About the application

Application number: 2025/91657	
What is the application for?:	Erection of first floor side extension (within a Conservation Area)
Address of the site or building:	Kelvin Villa, 1, Newsome Street, Dewsbury, WF13 4HE
Postcode:	WF13 4HE

PROPOSED FRONT ELEVATION
1:100 @ A1

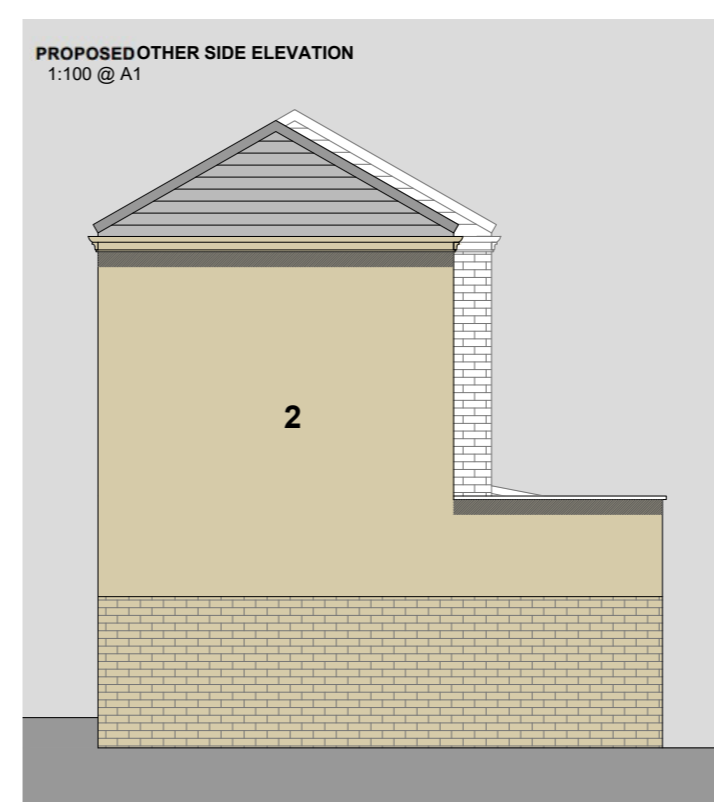
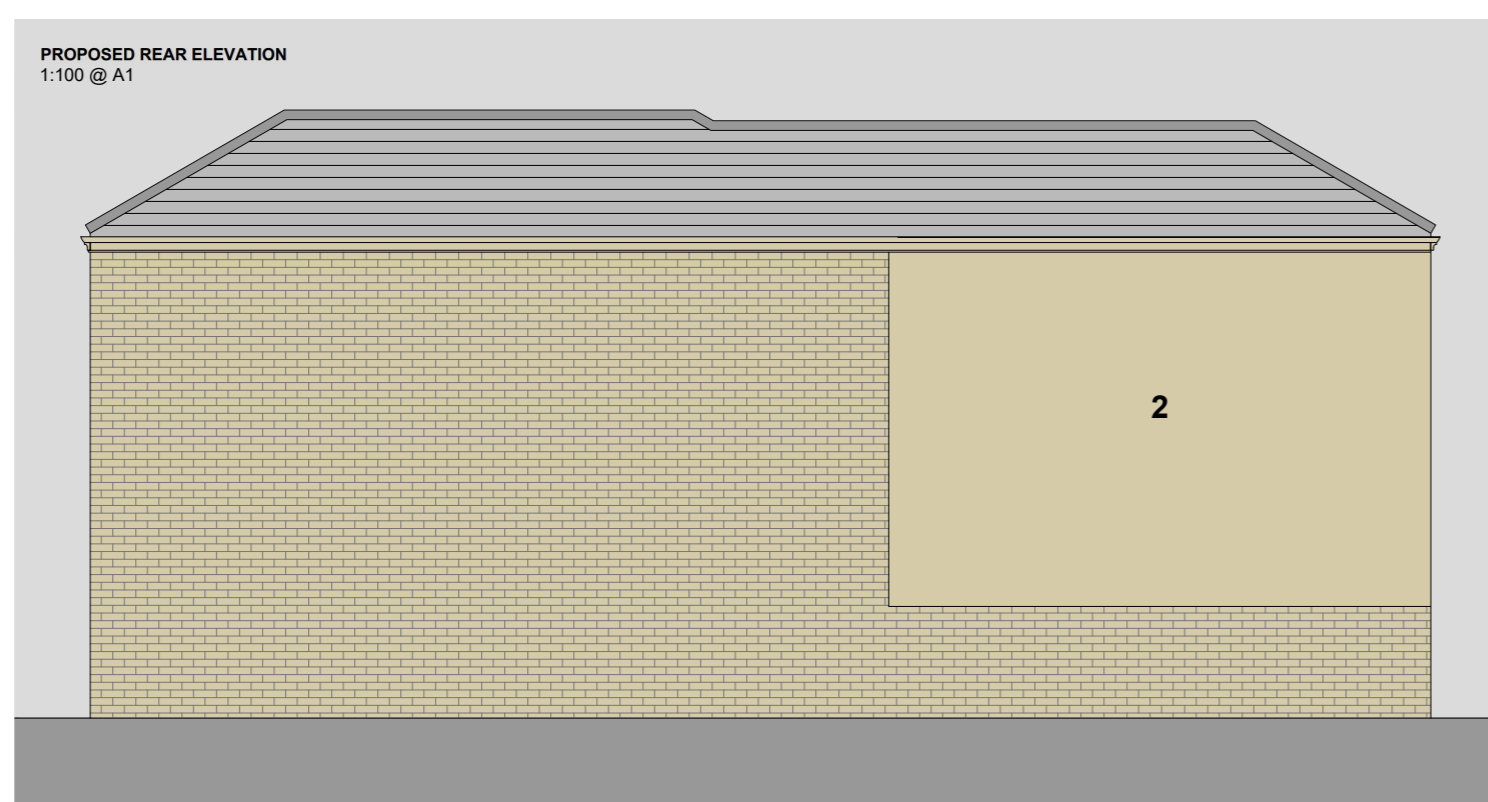
Type of comment: An objection	
Do you wish your comments to be published on the website anonymously?	<input type="checkbox"/> Yes
<ul style="list-style-type: none">•The proposed extension is overbearing and will significantly impact the visual amenity of our property due to its proximity and height.•The extension will result in a loss of privacy, as it overlooks our garden and living areas.•The proposed development will cause unacceptable overshadowing of our garden, particularly during the afternoon and evening.•The design of the extension is out of character with the surrounding buildings and will detract from the overall appearance within a conservation area.•The increased height and bulk of the extension will make our property feel enclosed and cramped.•Detailing and materials twill be poorly matched with the area.•Design will be out of scale and character within a conservation area by using rendering.
